## Application for EPE for an Order Granting Development Consent

### Traffic and Access Impacts, Local Highways and Site Visit Adequacy

This submission raises concerns regarding the robustness of the Applicant's assessment of construction traffic associated with Site B, particularly in relation to access points SA03–SA06 on Great Staughton Road. It also highlights the interaction with existing agricultural use of this route and the importance of the Examining Authority's site visit in fully understanding both highway constraints and the wider landscape context. It also raises concerns about the limited site visit to Hoo Farm.

Drawing Title
**Proposed Site Access
Sheet 1 of 5**

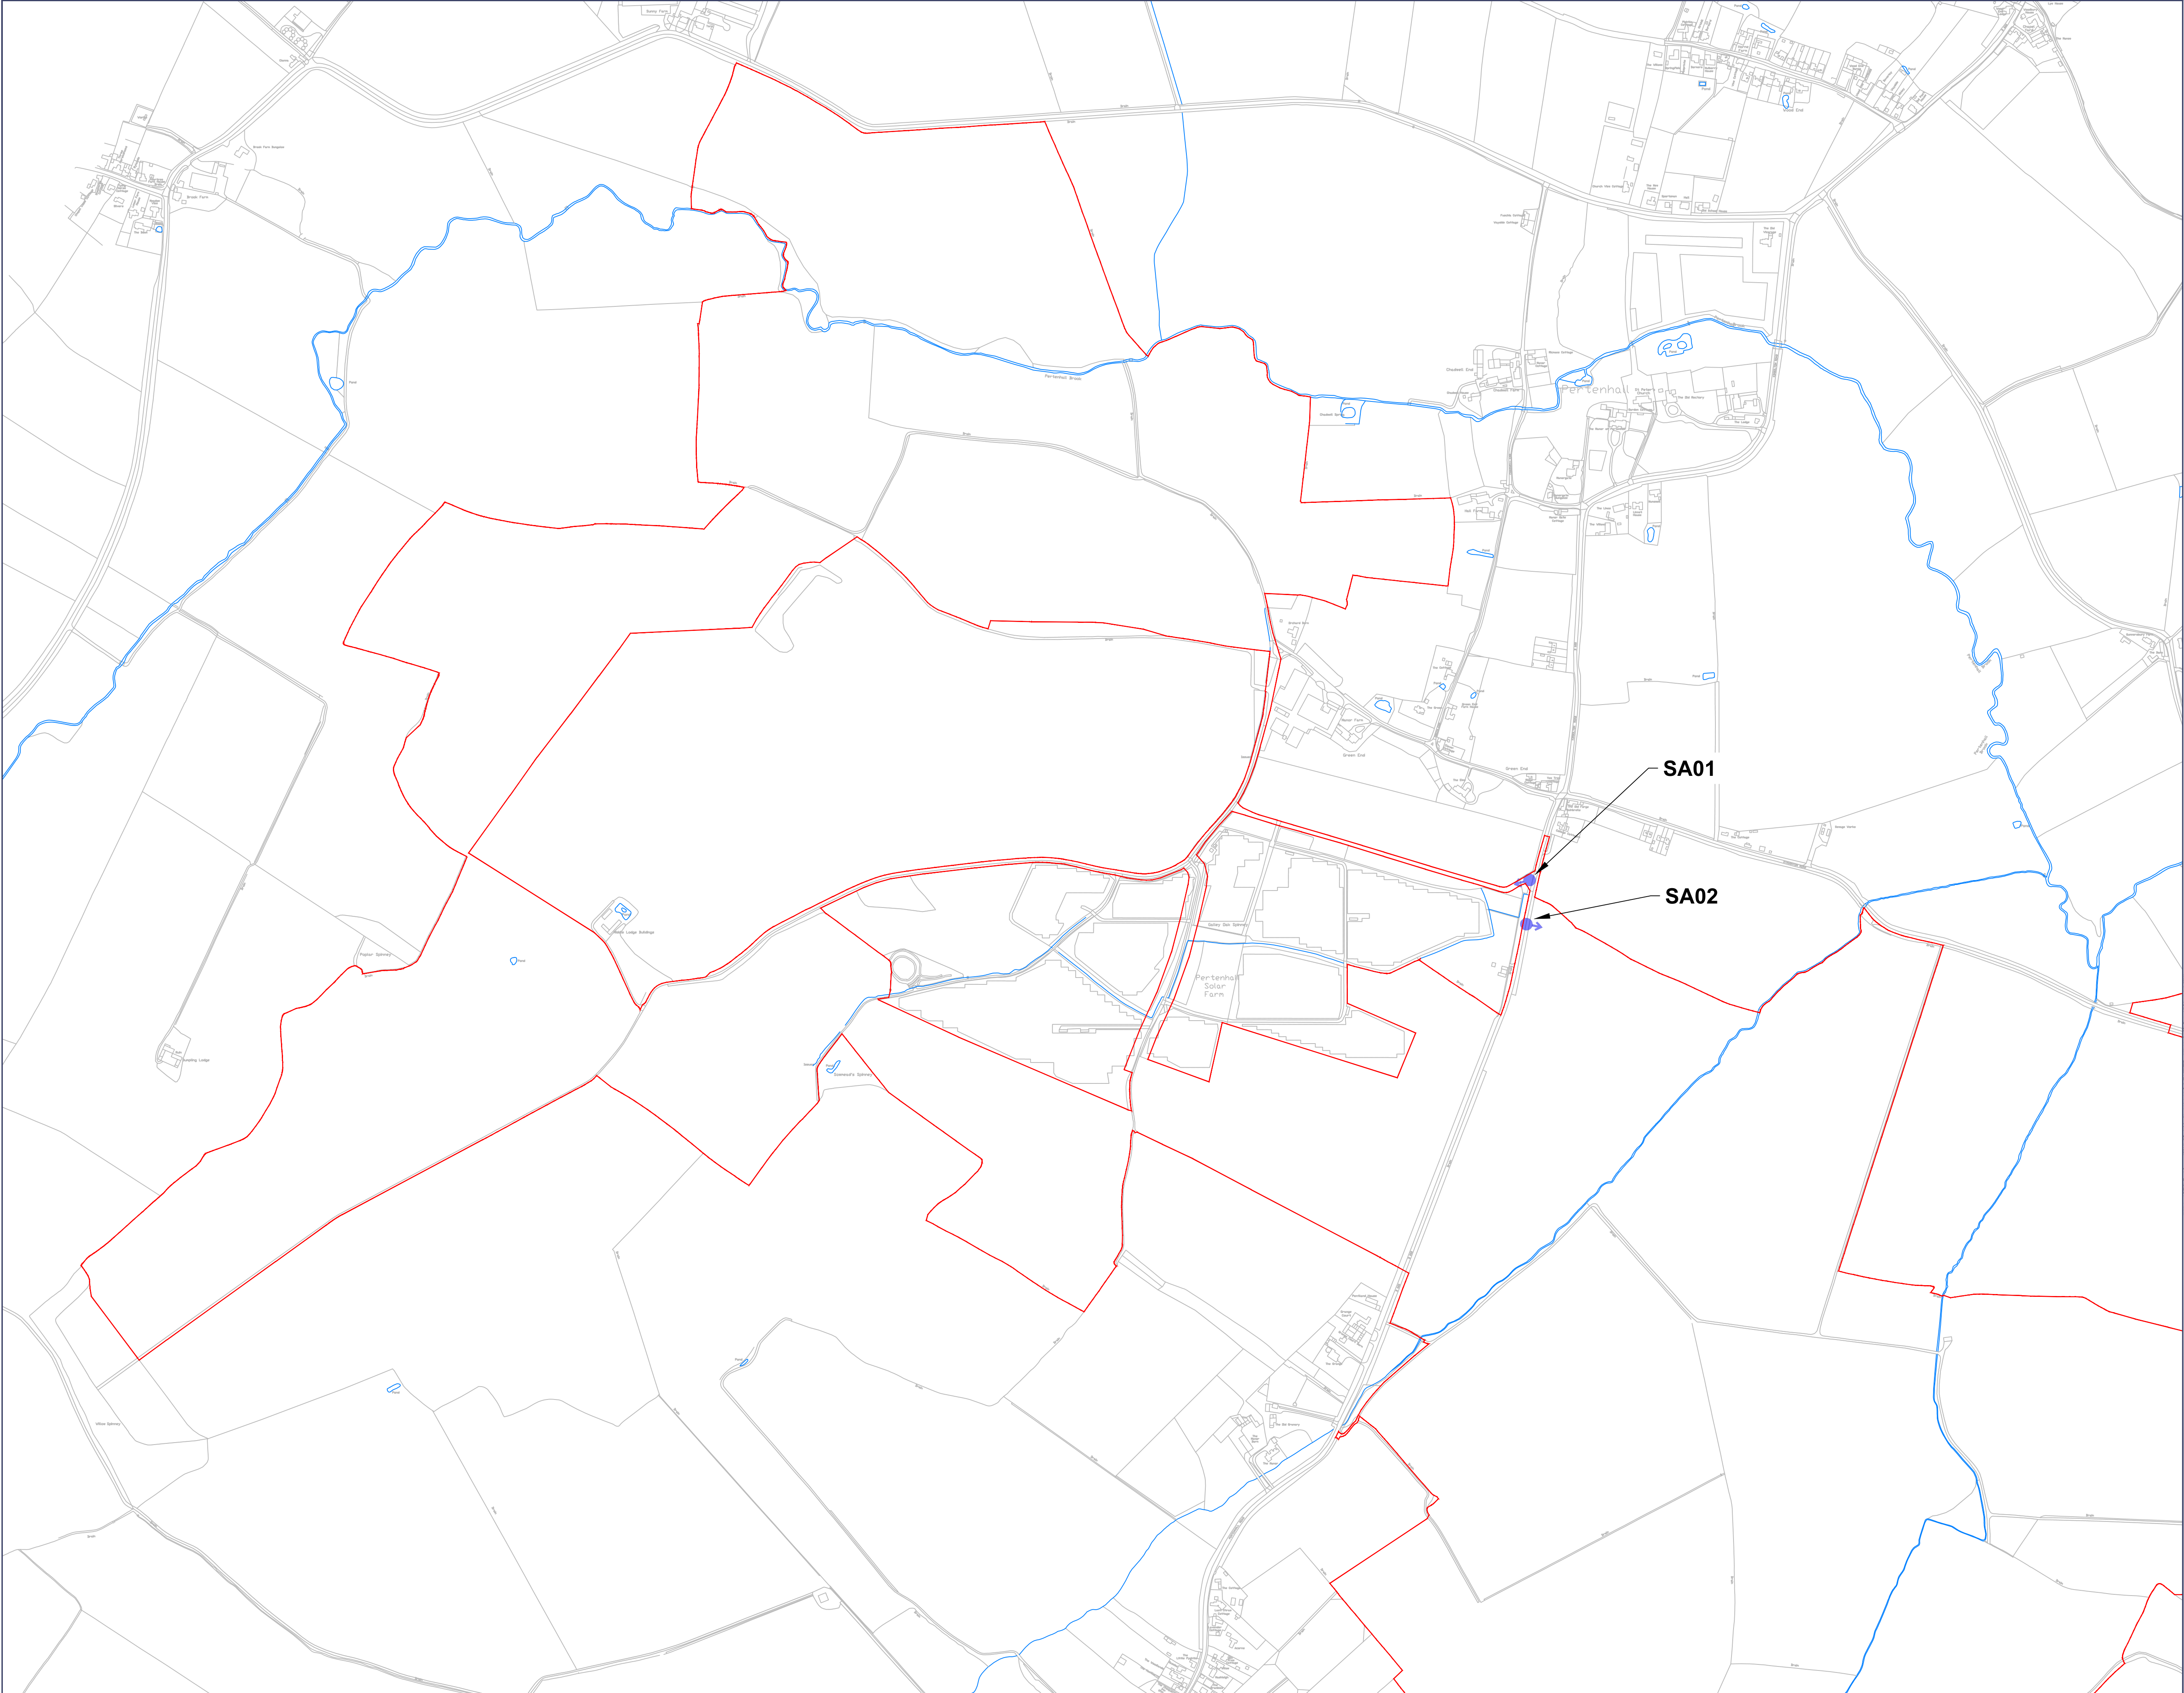
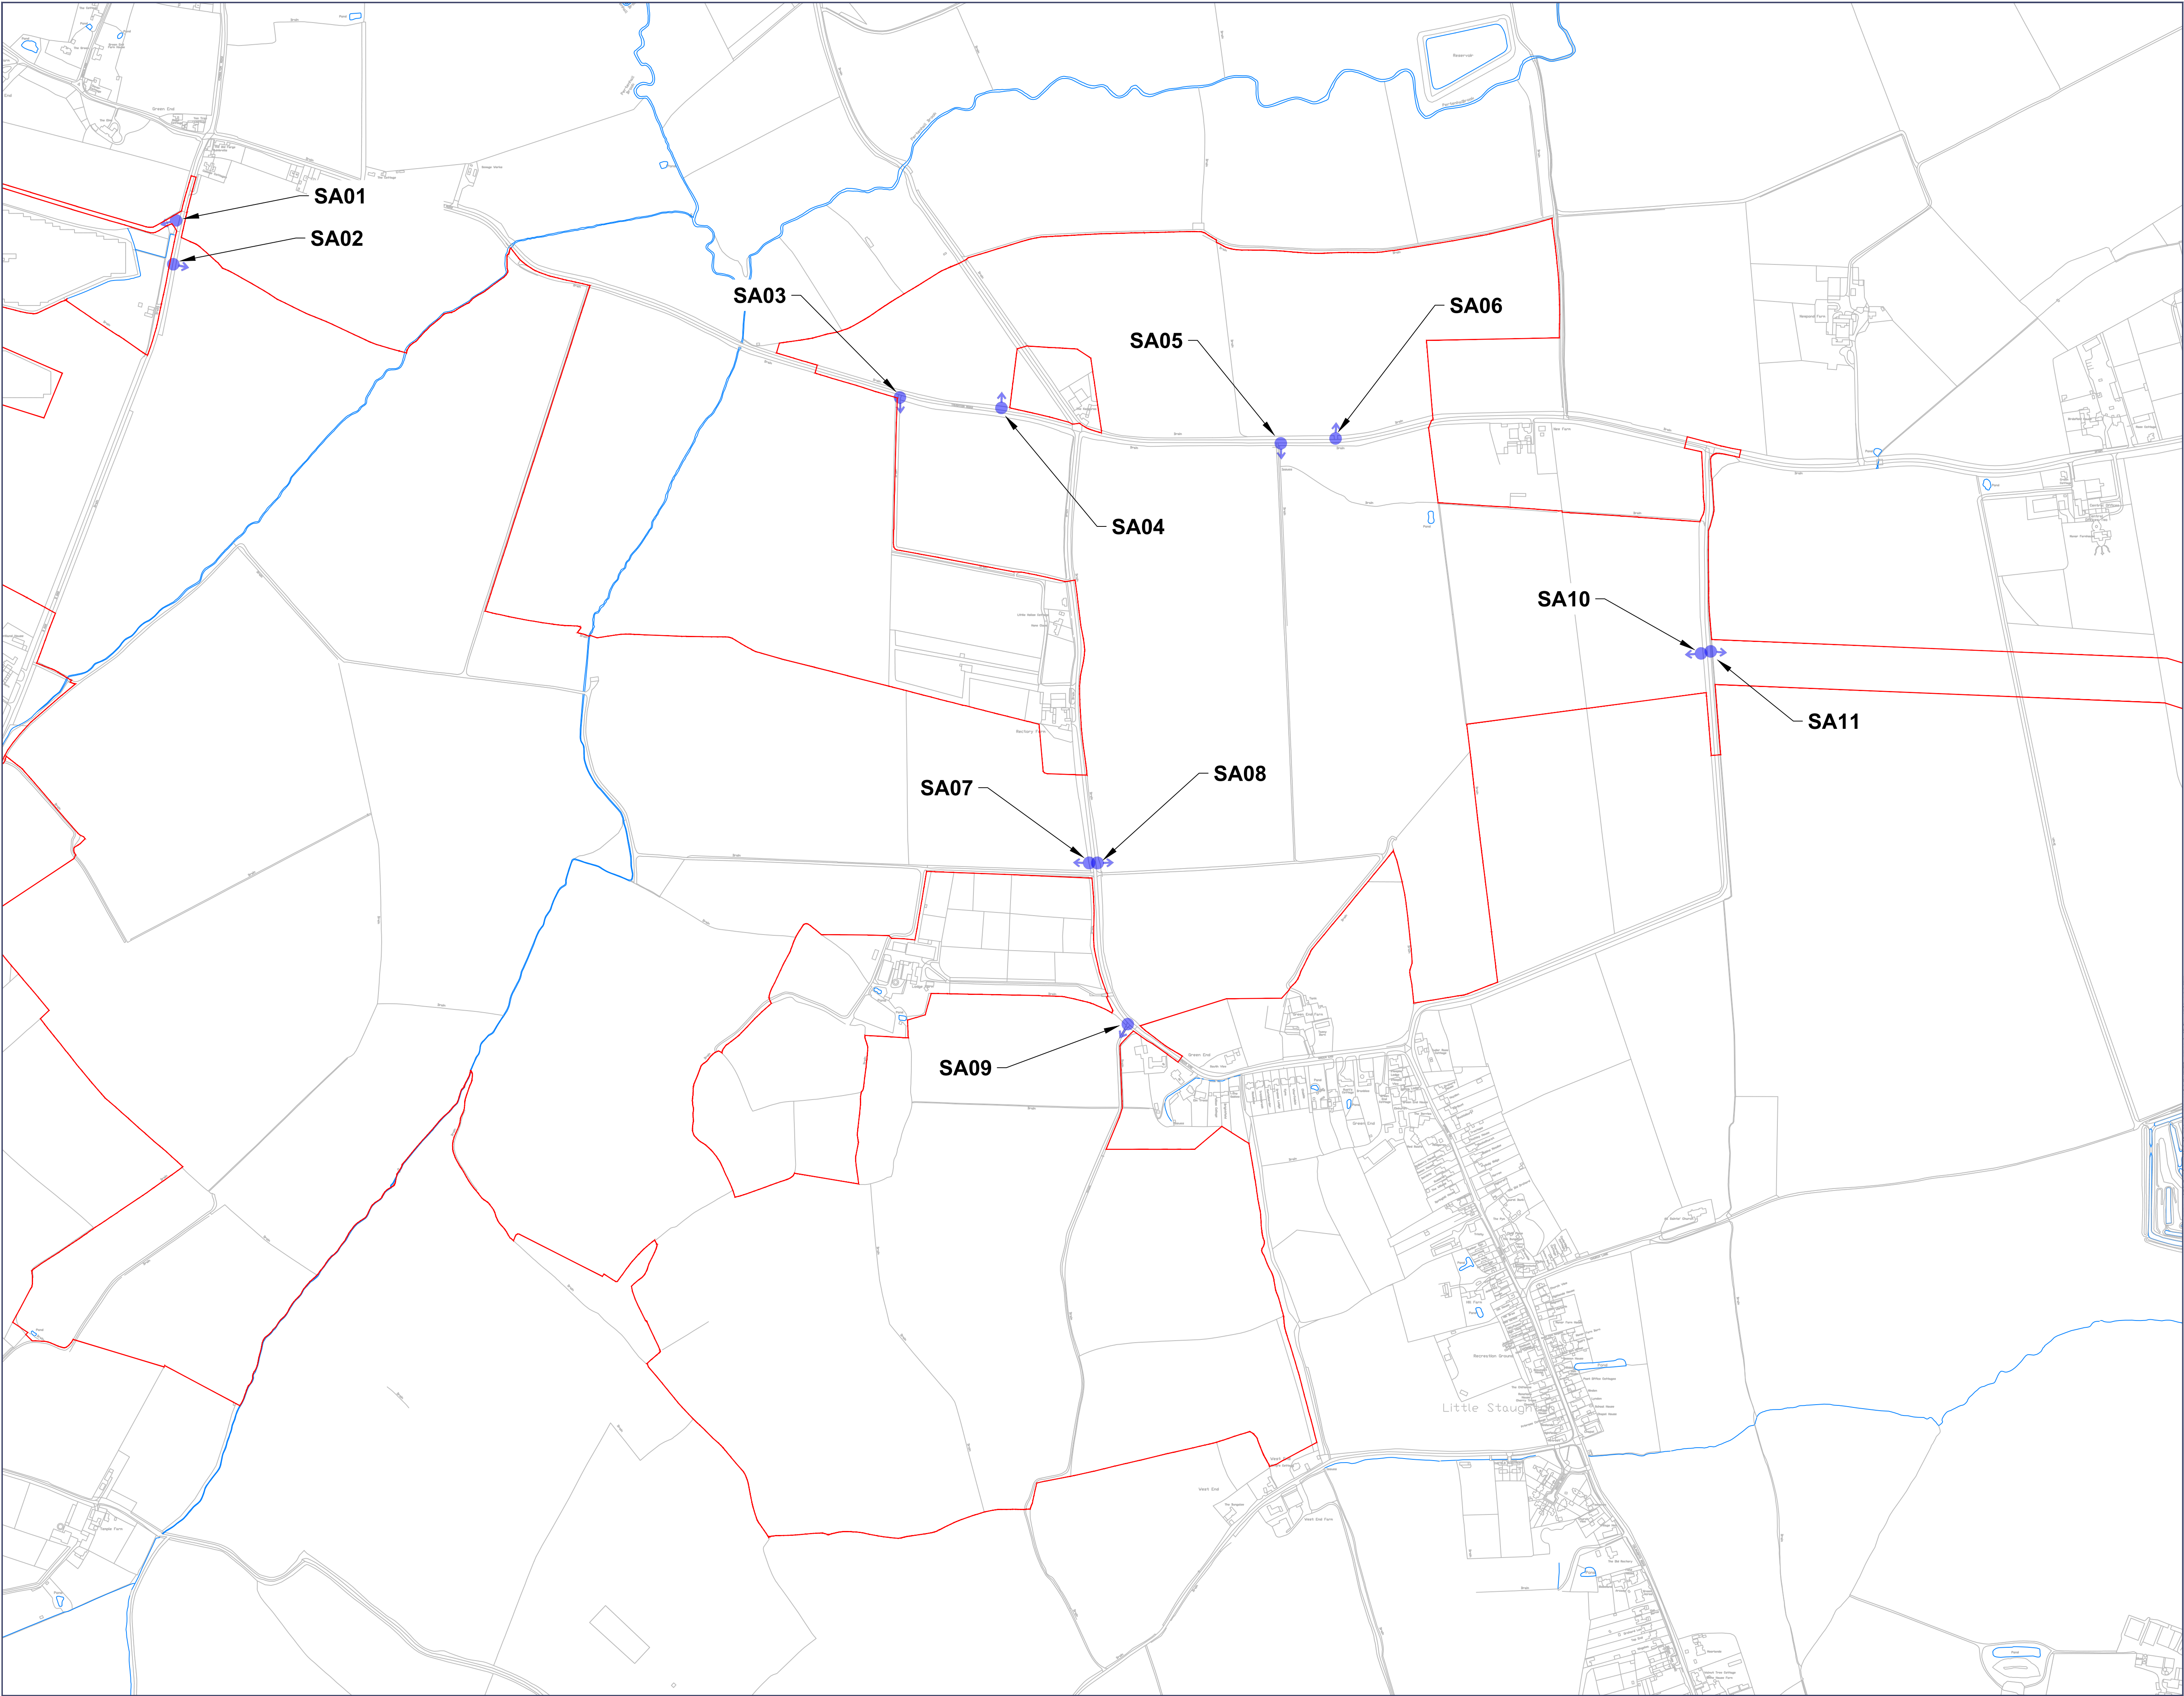
The Applicant's Outline Construction Management Plan (Sections 5.1.8 and 5.2.1–5.2.2) identifies multiple access points serving Site B from Great Staughton Road (SA03, SA04, SA05 and SA06), including the upgrading of existing field gate accesses to accommodate construction traffic.

However, the accompanying traffic-flow information appears to assign only minimal construction vehicle movements to these access points, despite the scale of development proposed.

- SA03 serves approximately 4 hectares
- SA04 serves approximately 6.25 hectares
- SA06 serves approximately 20 hectares

The application does not explain how these areas can be constructed with such limited access movements. For clarity, a detailed breakdown of construction traffic by access point and activity type (including HGVs, deliveries, staff vehicles and plant) is required, rather than aggregated site-wide totals.

- Break down construction logistics by access point
- Explain delivery volumes or frequency
- Clarify workforce access arrangements
- Identify plant and machinery movements
- Set out any internal haul or distribution strategy

1. Require a detailed breakdown of construction traffic by access point (SA03–SA06) and activity type
